01 July 2021

Application No: SSD-8706

**Re: Randwick City Council submission on the State Significant Development SSD-8706 – Night Racing at Royal Randwick Racecourse (SSD-8706)**

Figure 1 – Overlay of proposed works on areas of identified archaeological significance from GML 2006 CMP.

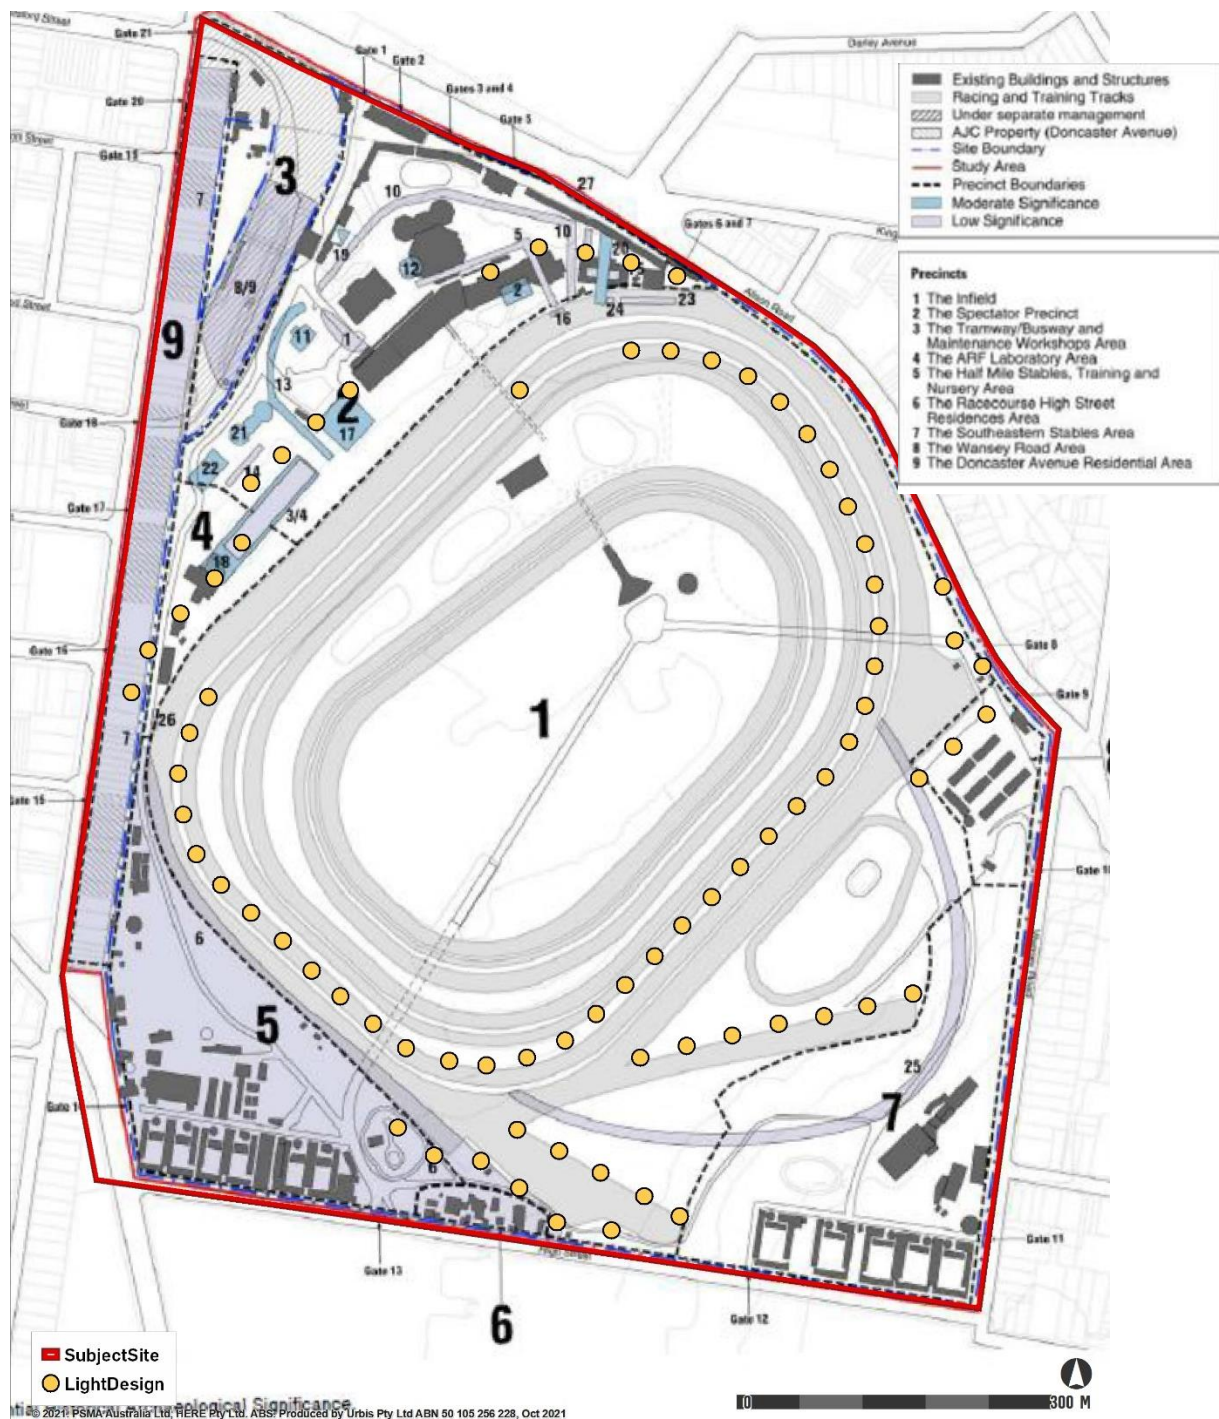
37. The Heritage Impact Statement prepared by Urbis includes the Potential Historical Archaeological Significance mapping from the 2006 Godden Mackay Logan Conservation and Management Plan for the site which identifies areas on the site having Moderate Significance and Low Significance in relation to historical archaeological sensitivity. No assessment of the proposal in relation to this mapping has been provided however, and the SSD submission is deficient in this regard.
38. The Potential Historical Archaeological Significance mapping identifies a number of sites within the Spectator Precinct and the ARF Laboratory Area, associated with previous structures, as being of Moderate significance and it is unclear whether excavation for the footings of the proposed light columns will impact on these archaeological values.

Figure 2 Light Pole locations A11, A12, A13 and trees 1, 2 and 3

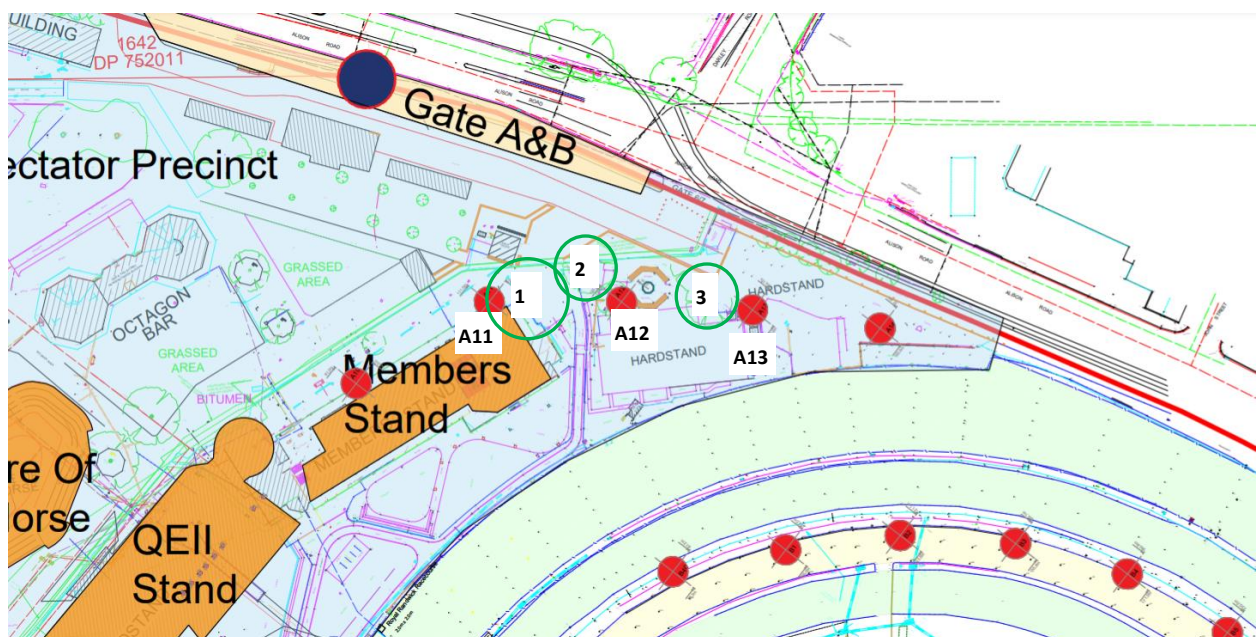
27. Concerns are raised over the potential impact of the proposed lighting column locations on existing significant trees. The Visual and Landscape Impact Report prepared by Sturt Nobel and Associates identifies three lighting columns in close proximity to exceptionally significant trees and three columns located in close proximity to existing trees of high significance. Potential impacts have been identified including damage to tree roots and incursion into Tree Protection Zones (TPZ). The Report recommends that physical assessment should be re-reviewed in consultation with an arborist at detailed design stage. Further, the EIS states that the exact final location of columns may vary up to 10% due to arborists advice during detailed design.

28. Council does not support the removal or substantial pruning of trees listed as significant under the Randwick Register of Significant Trees. As such, Council recommends that an Arboricultural Impact Assessment be undertaken as part of the SSD assessment and prior to the detailed design stage to ensure the proposal will not result in unacceptable impacts to Council's Register of Significant Trees.
